From: [Ken Edwards](#)
To: [Chace Pedersen](#)
Subject: RE: ACU-24-00001 Horizon Towers - Notice of Application
Date: Tuesday, August 6, 2024 9:40:28 AM
Attachments: [image001.png](#)

Project Name Horizon Towers

Case Number ACU-24-00001

TO: All Staff
FROM: Public Works Plan Review Team
DATE: August 21, 2024
SUBJECT: ACU-24-00001 Horizon Towers

Critical Areas Map

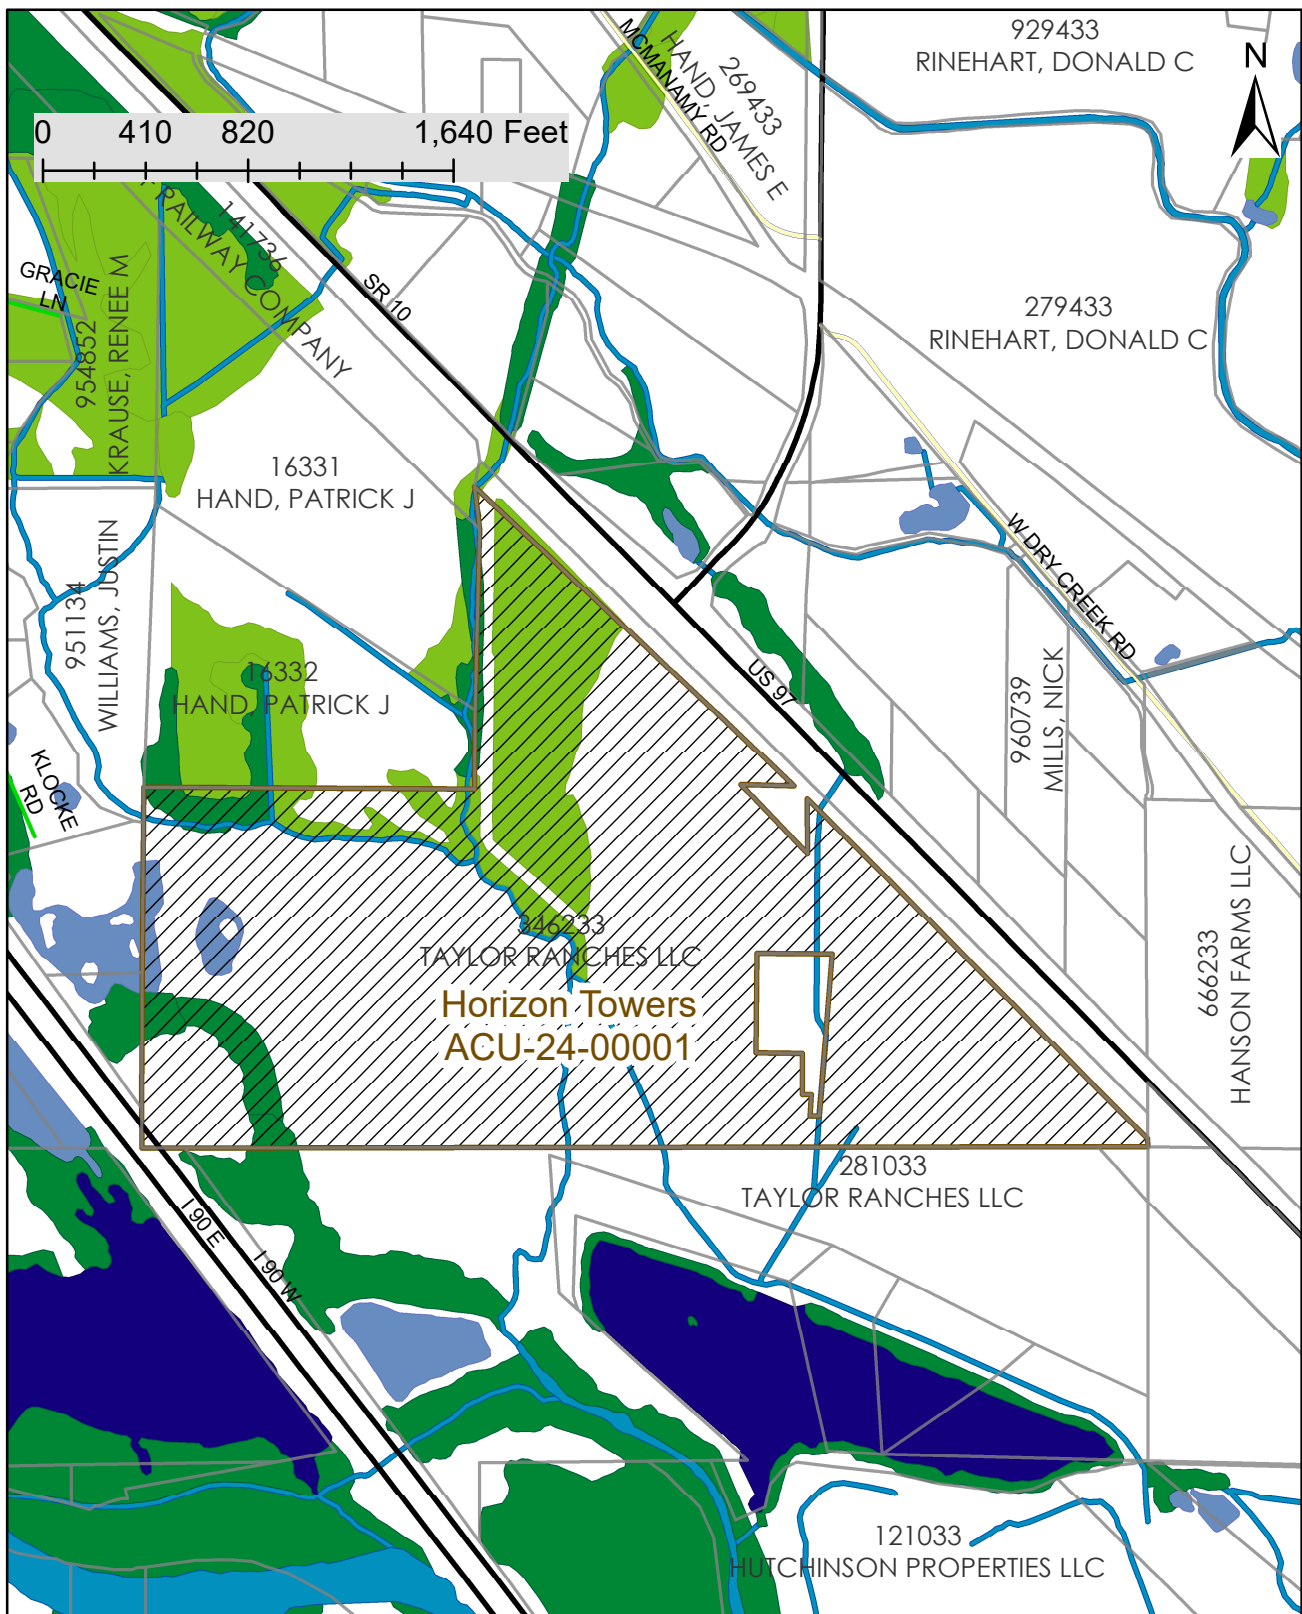
FLOOD	A portion of parcel #346233 is located in a FEMA identified special flood hazard area (100-year floodplain). A floodplain development permit is not required for the project since the location of the proposed wireless facility is not within the mapped floodplain area. (SC)
WATER MITIGATION/ METERING	No comments. (SC)
AIRPORT	No comments. (JS)

TITLE
SITE PLAN

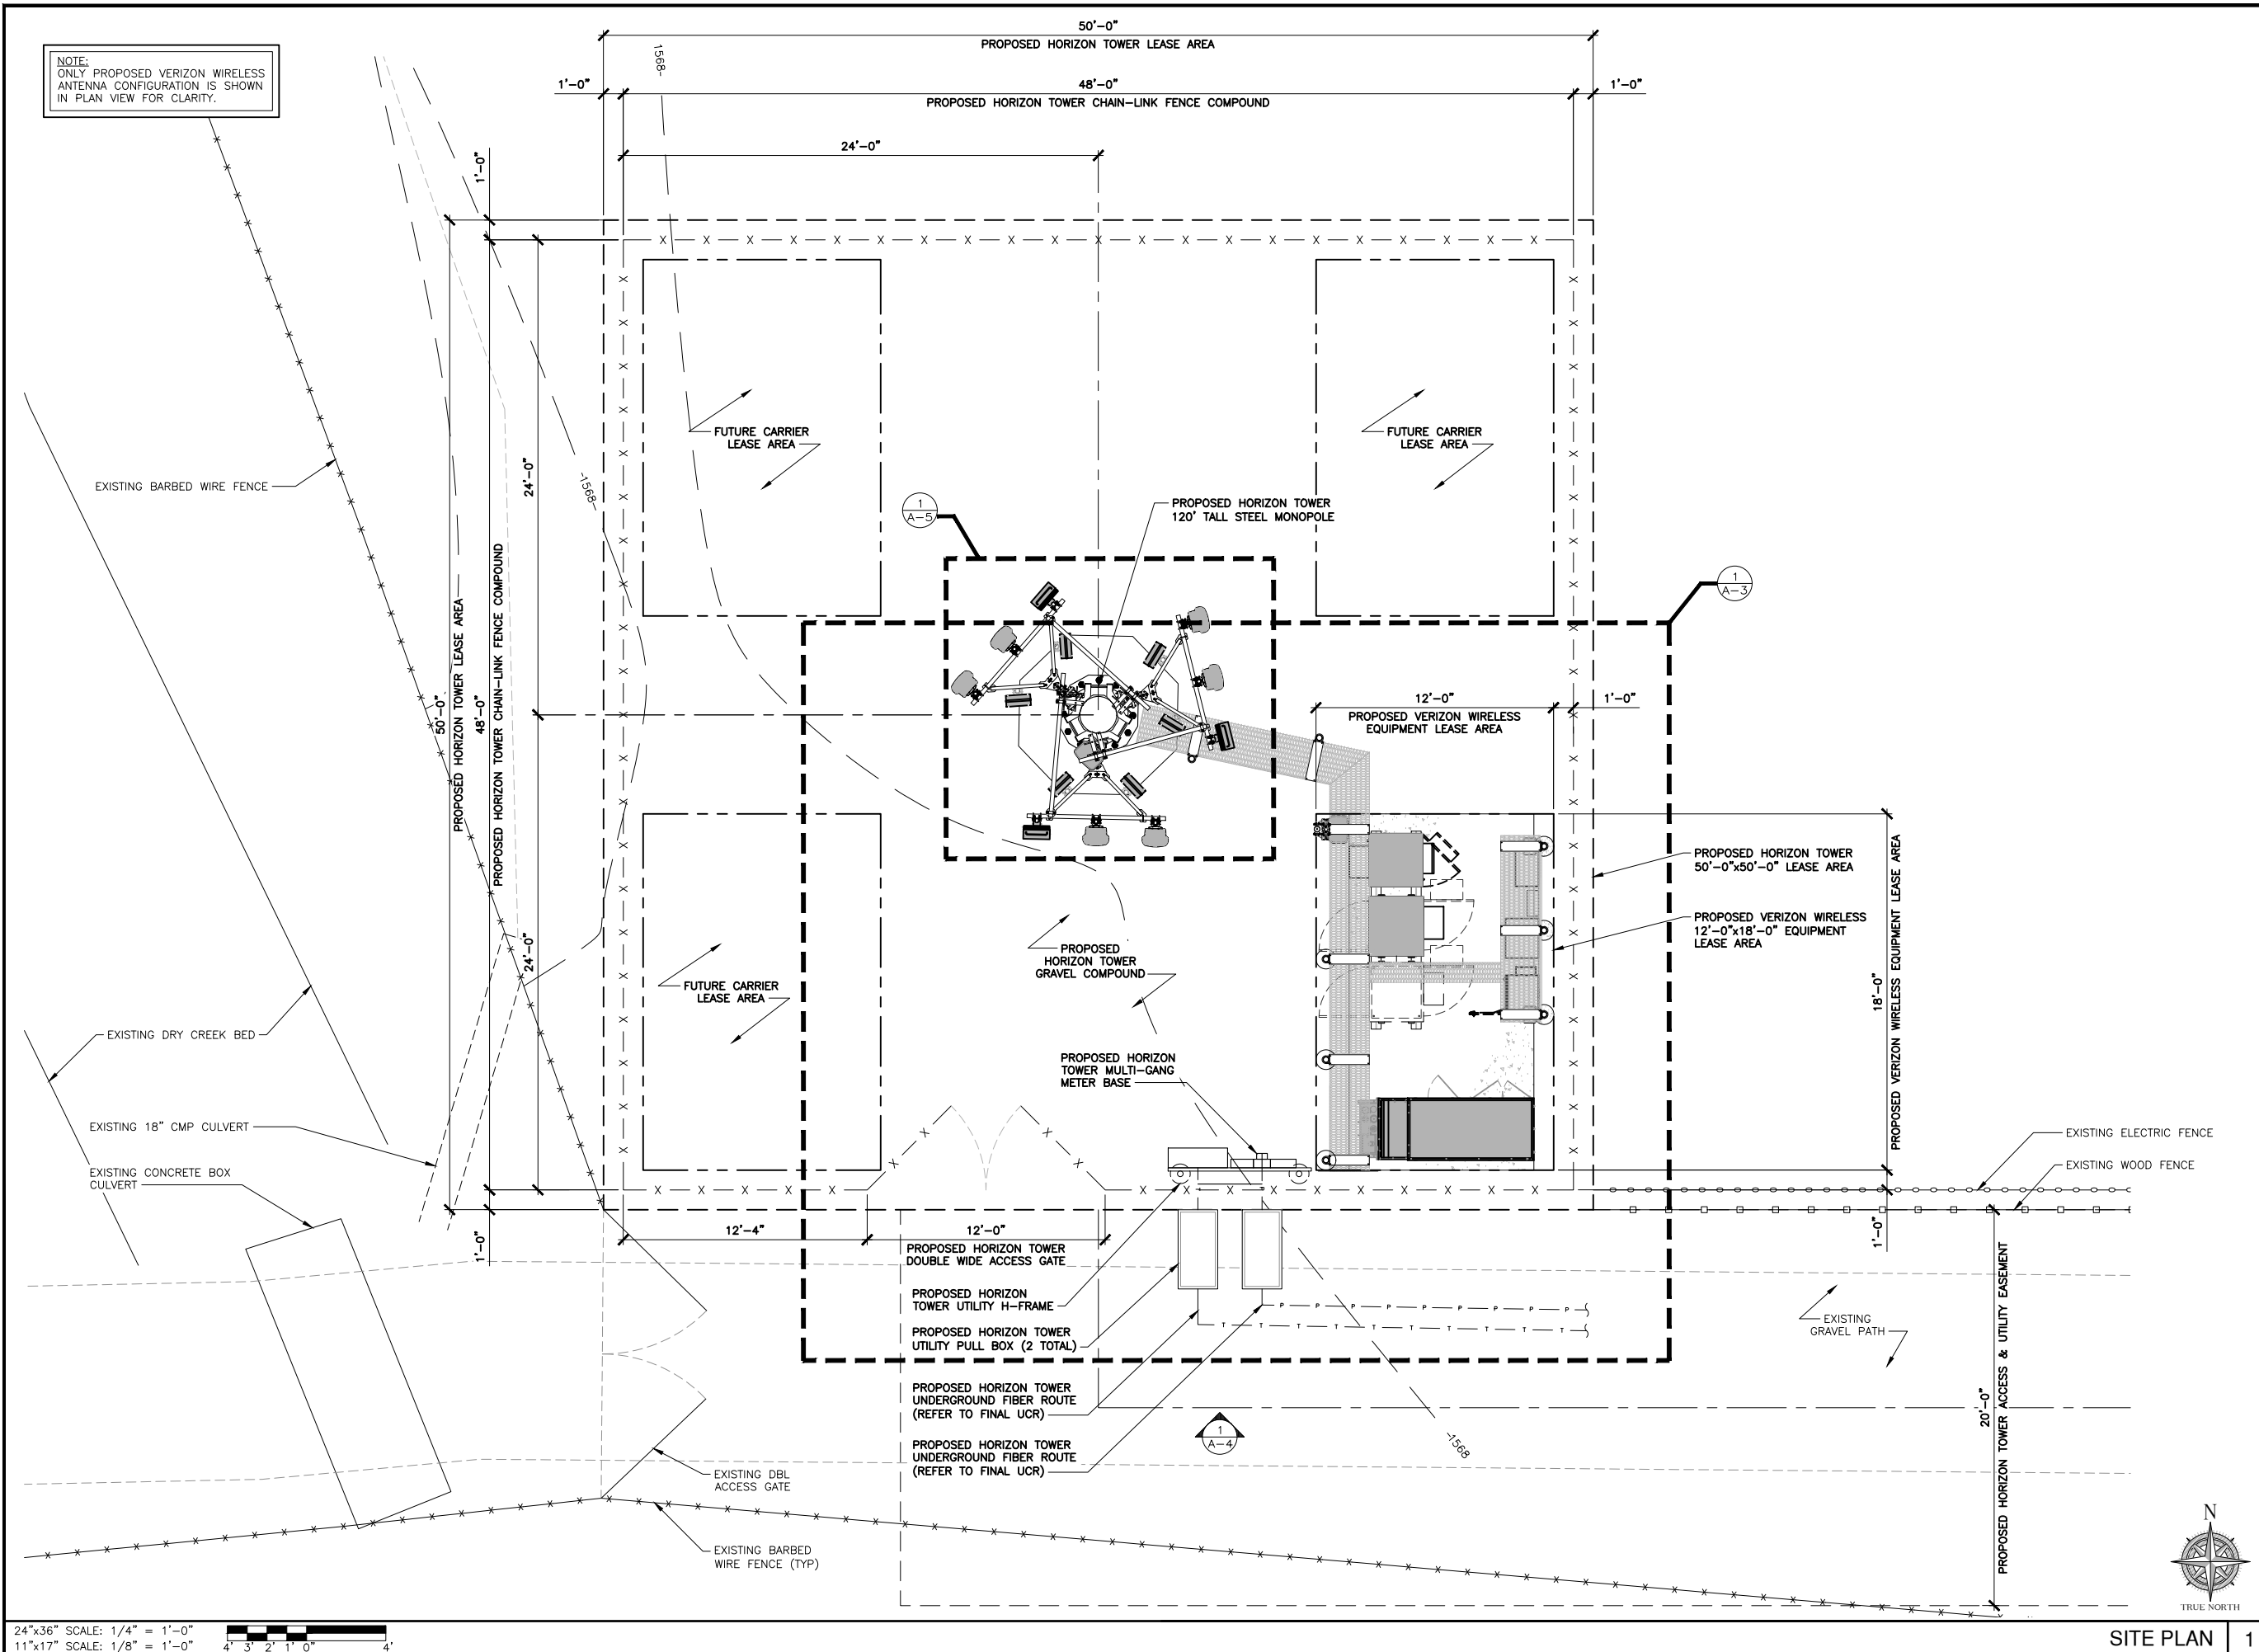
Fire apparatus access is required for this application. Provide fire apparatus access roads with an unobstructed width of not less than 20 feet, an unobstructed vertical clearance of not less than 13.5 feet, with an all-weather driving surface and capable of supporting the imposed loads of fire apparatus. Access roads shall extend to within 150 feet of all portions of the facility and all portions of the exterior walls of the first story of the building. Roads constructed in grades steeper than fifteen percent (15%) shall be constructed with Portland cement concrete with grooved surfacing.

Approved fire apparatus turnarounds are required for this project.

- The subject property is adjacent to U.S. Highway 97 (US 97), a Class 1 managed access highway with a posted speed limit of 55 miles per hour. Currently, access to the property is via the permitted joint use approach at milepost 136.09 left and a grandfathered approach at milepost 136.10 left. The permitted approach can be used but the permit must be updated. No additional approaches to US 97 will be allowed. The property owner is required to contact Mark Kaiser of the WSDOT - South Central Region Office at (509) 577-1668 to update the permit.
